Response to Submissions

Precinct 4A, RNSH

St Leonards Health Organisations Relocation
(SHOR)

19 June 2018 | 16611

GA PLAN - GROUND LEVEL

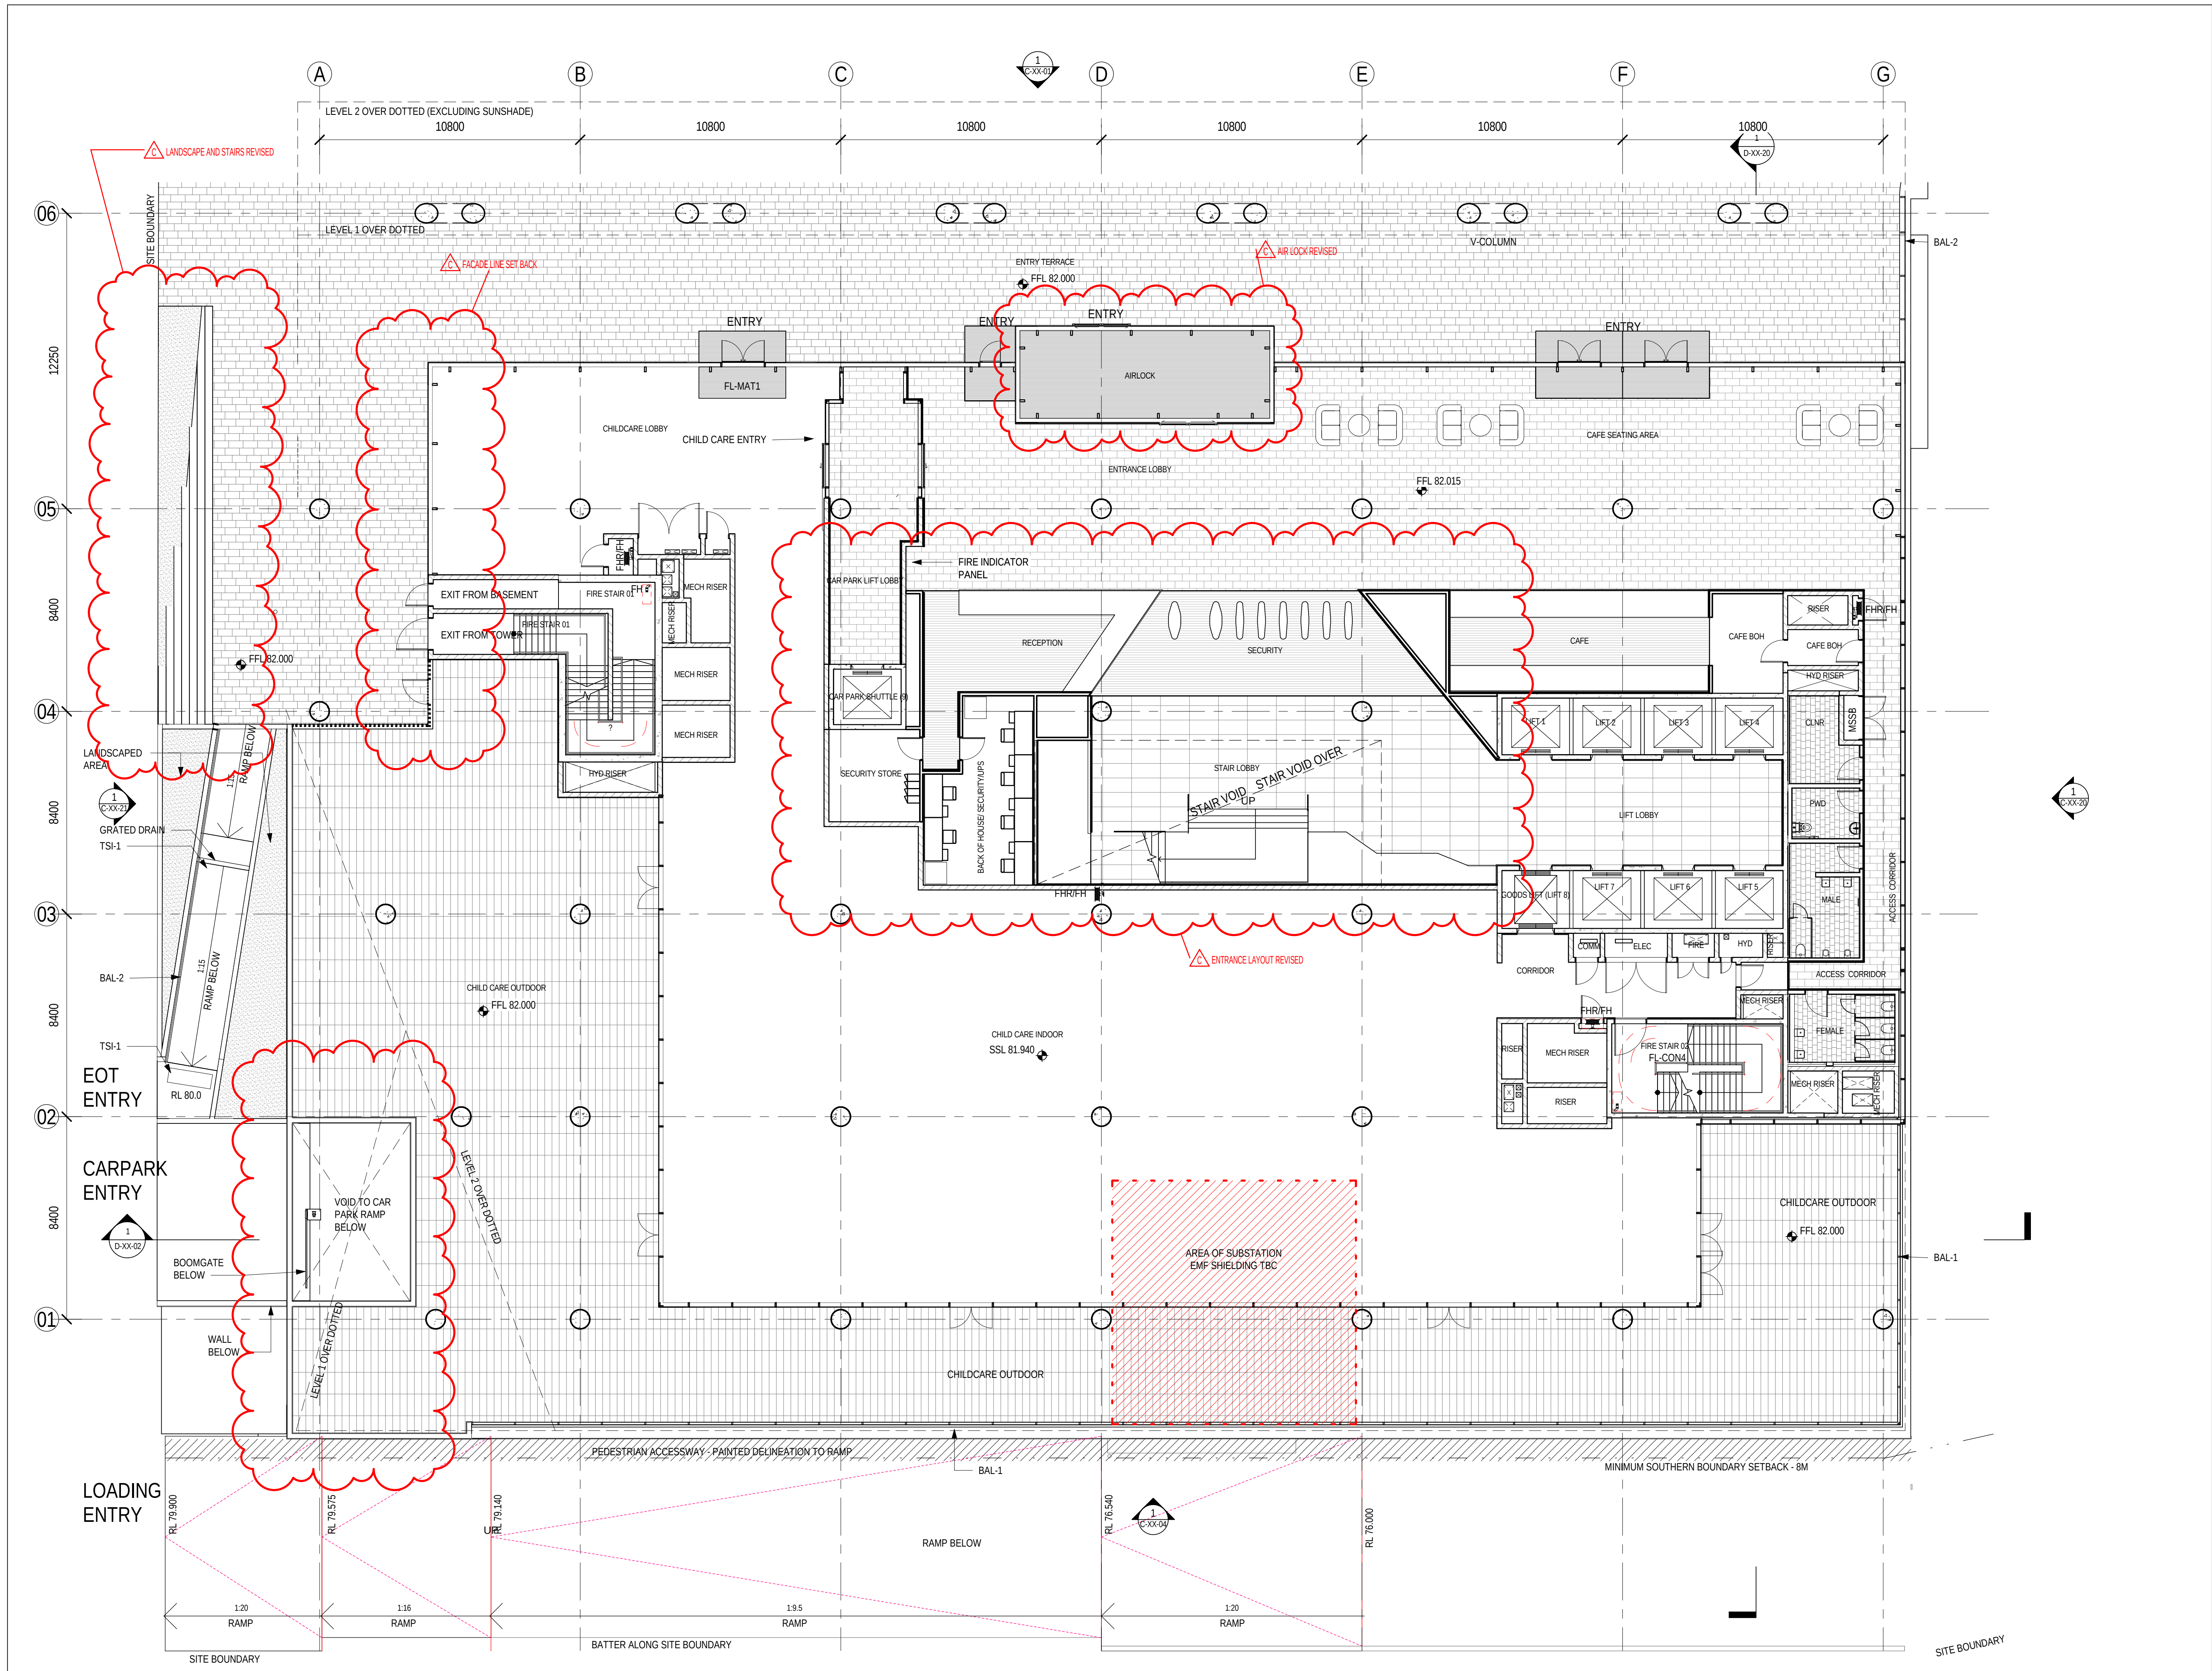
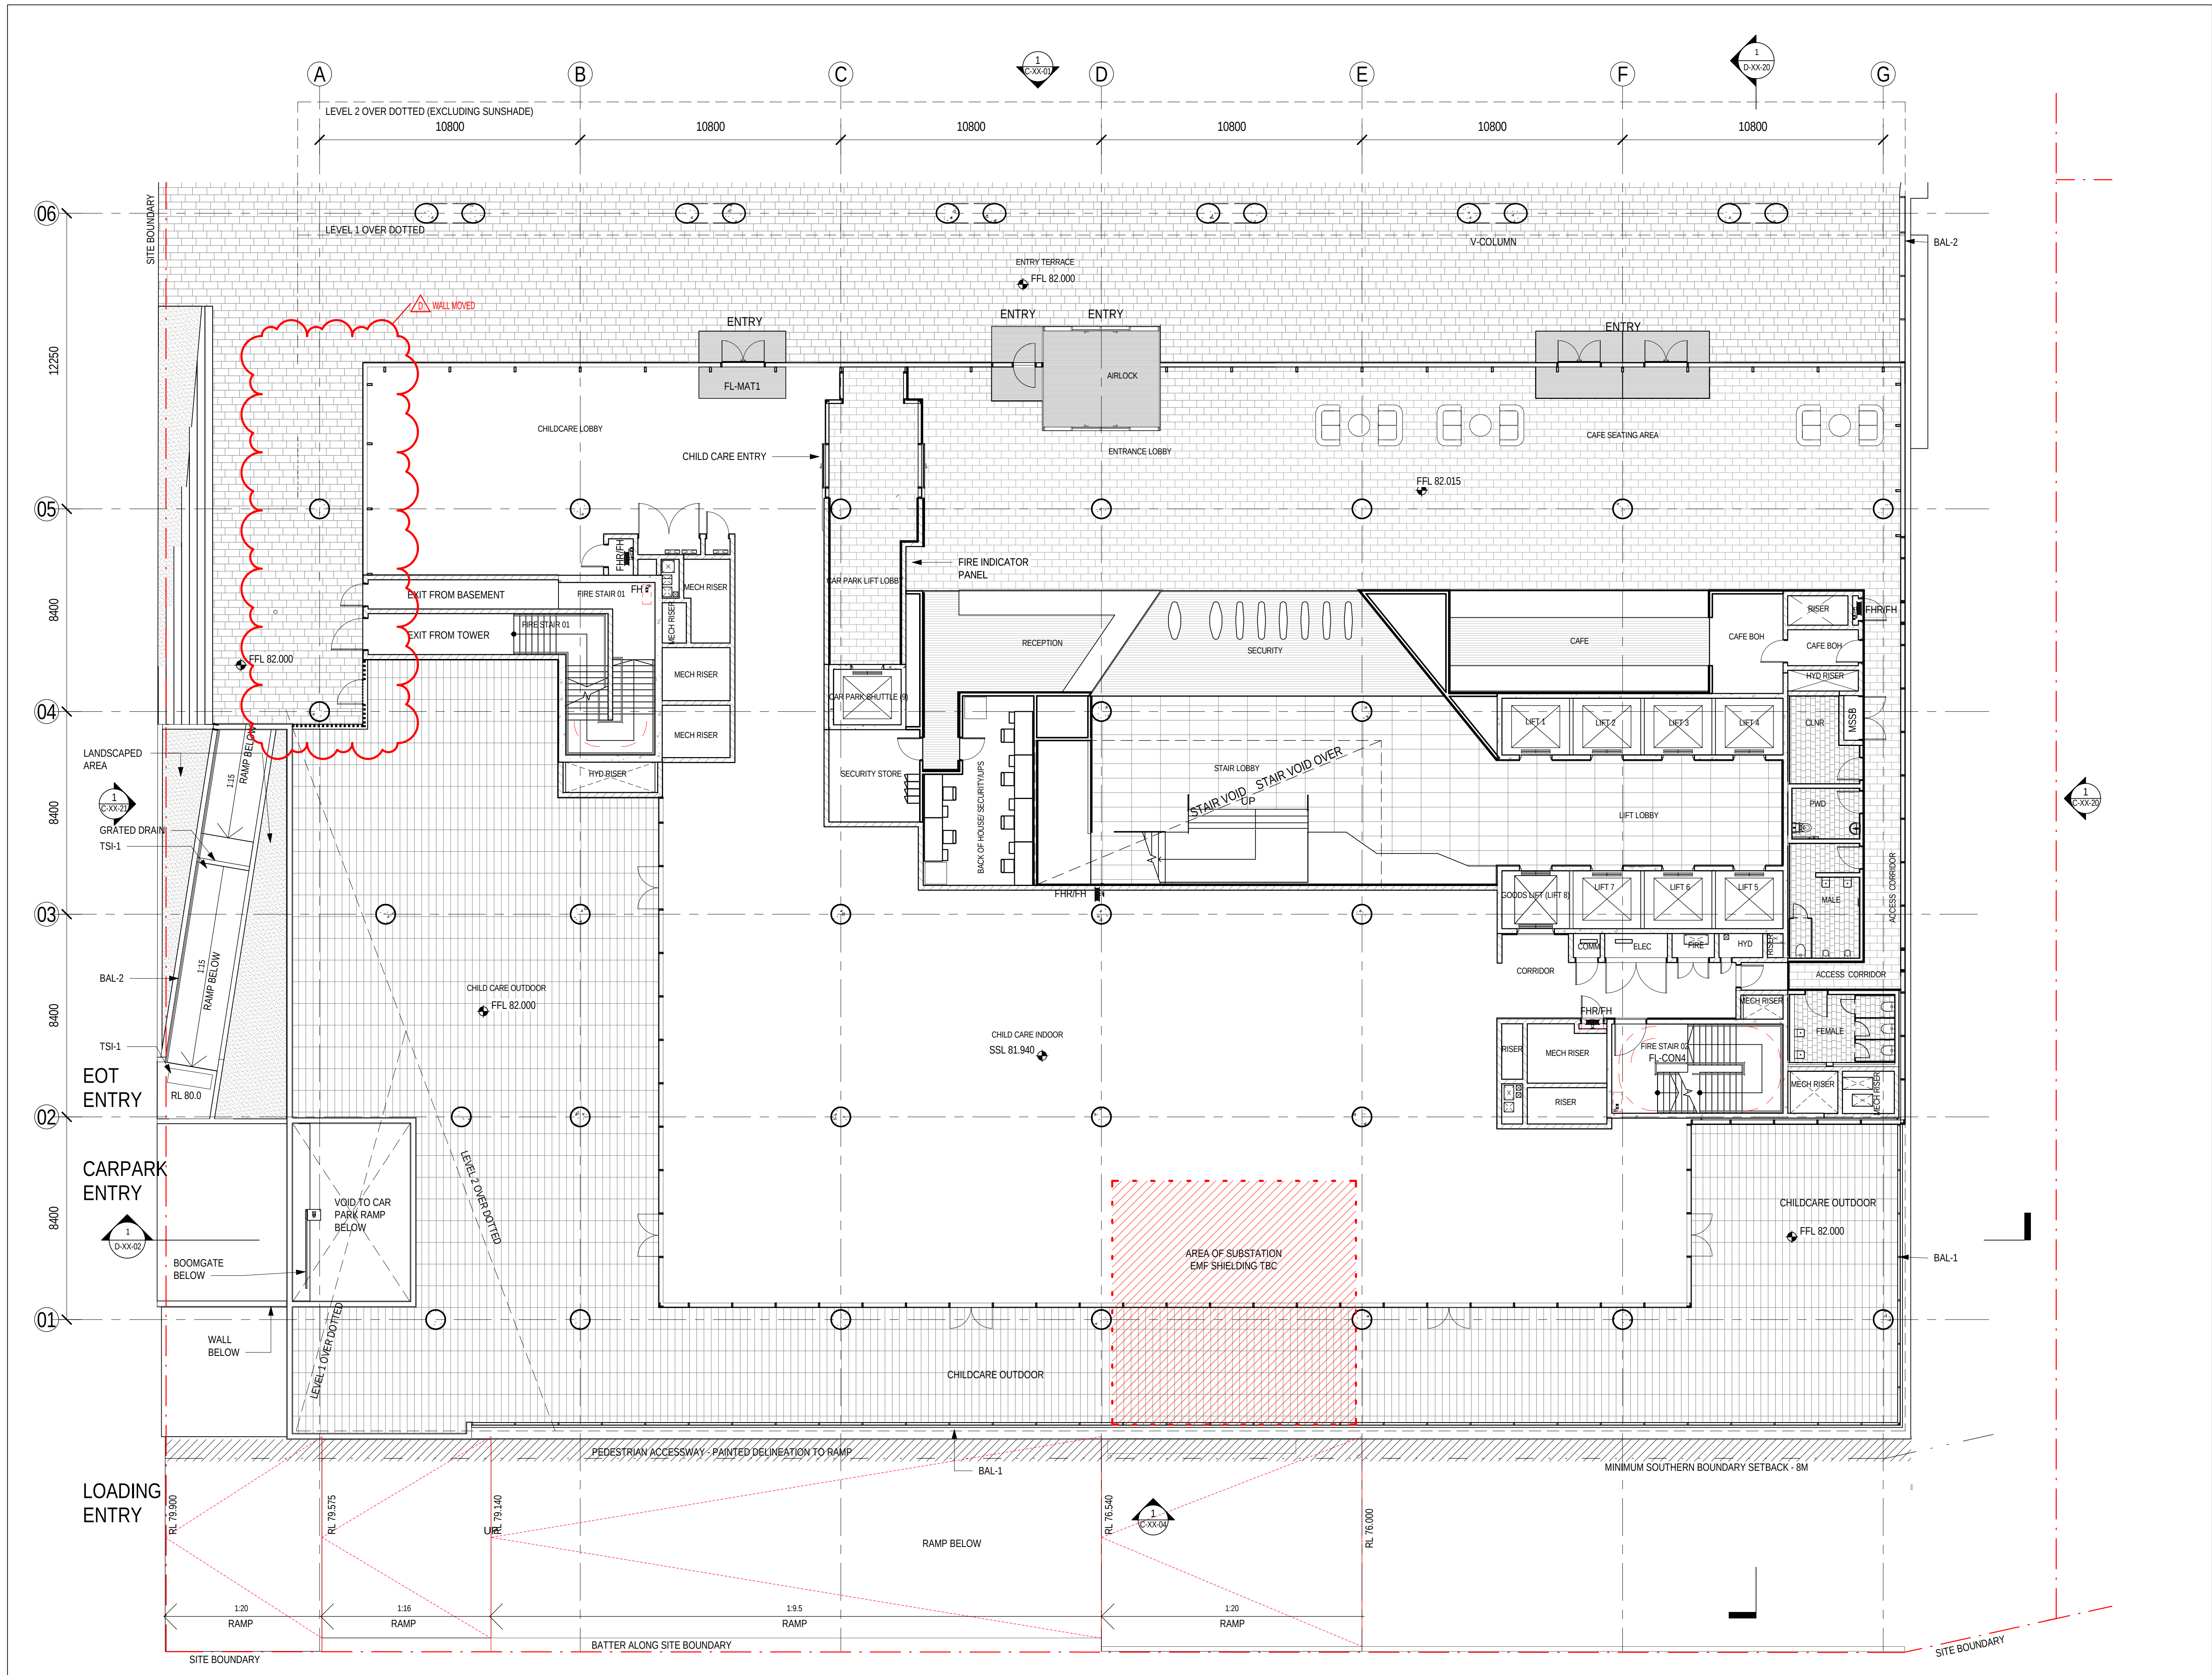
Issues Raised by Agencies and Organisations		Proponent's Response
Department of Planning & Environment		
Subdivision		
The proposed subdivision boundary alignment must be amended so it is clear of the south-eastern corner of Building 36 (i.e. deletion of proposed Lot 42). Alternatively, evidence must be provided demonstrating how Building 36 will comply with the Building Code of Australia at the boundary between proposed Lot 40 and Lot 42.		- Lot 42 is to be created as per the application and the attached plan (Attachment A). - Building Code of Australia compliance for Building 35/36 will be achieved via the creation of additional easements upon Lots 41 & 42 to ensure that all BCA requirements can be achieved by Building 35/36 - The details of these easements will be provided prior to registration of the subdivision.
View Loss		
An assessment of the potential view loss impacts generated by the proposed development is to be undertaken, particularly the impacts on existing residents located in unit buildings in Herbert Street.		- An assessment of the potential view loss impacts generated by the proposed development on the existing residents located in units on Hebert Street has been prepared by BVN and is submitted with this table at Attachment B. - As illustrated in the BVN response, the western view from the upper levels of residences along Herbert Street is towards the greenery of Gore Hill Oval across the rooftops of aging low-rise building on the RNSH campus, and is bordered by the red brick building 36 to the north and 207 Pacific Highway to the south. - The new development is located in the centre of that view. - On the lower levels (level 11) the view of the greenery is partially obscured; however, visibility is maintained either side of the building, and the sky view is not obstructed. - On the upper levels (level 21), there is distant views to the Parramatta River. These views are maintained over the rooftop of the new development. Greenery surrounding Gore Hill also remains visible.
